Powell Amenity Center
212 Perseus St. Lillington, NC

October 2nd, 2024

Attn: Harnett County Environmental
RE: Plan Review Comments

**1 POOL PIPING PLAN**  
 3/16" = 1'-0"

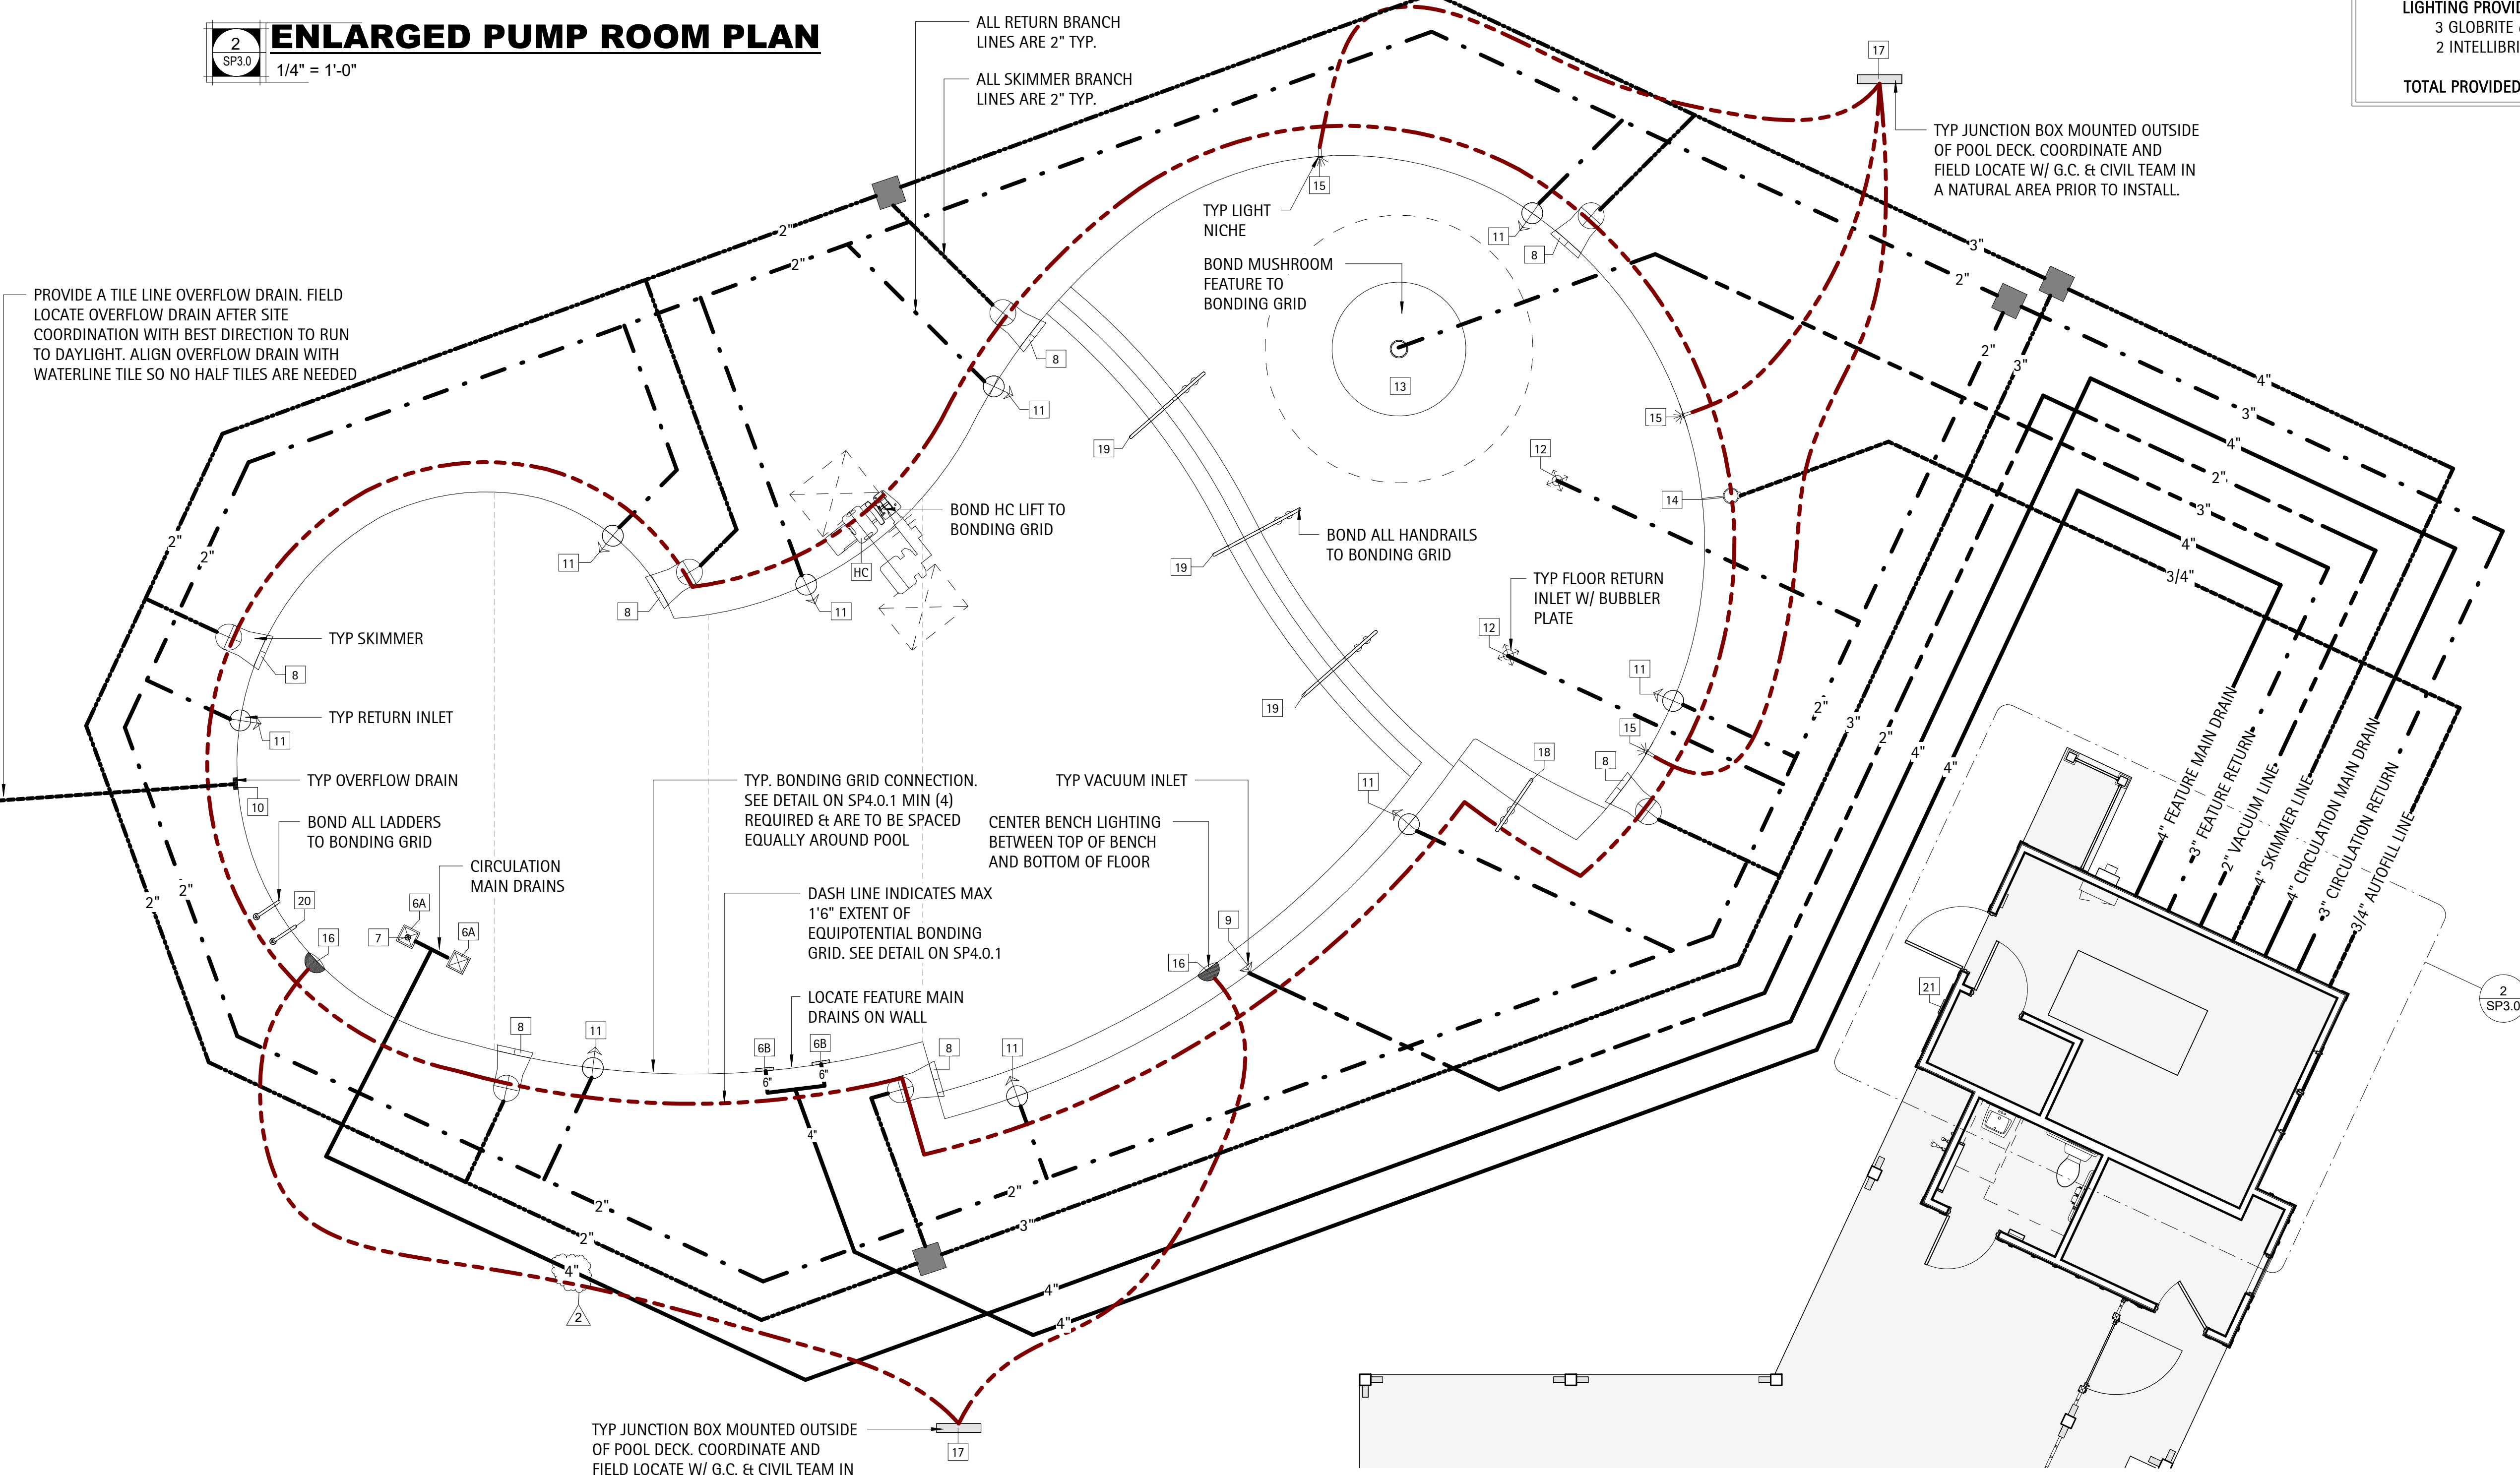
- Comment 1: Main Drain Line as drawn is specified as a 2" line. The main drain line shall be a 4" minimum line.
 - **This was an error and has now been corrected. See SP3.0 for changes.**
- Comment 2: The Circulation and Feature SOFAs have not been revised on the plans to show items indicated in the letter dated August 27. The circulation SOFA cannot be approved as drawn.
 - **See SOFA attached.**
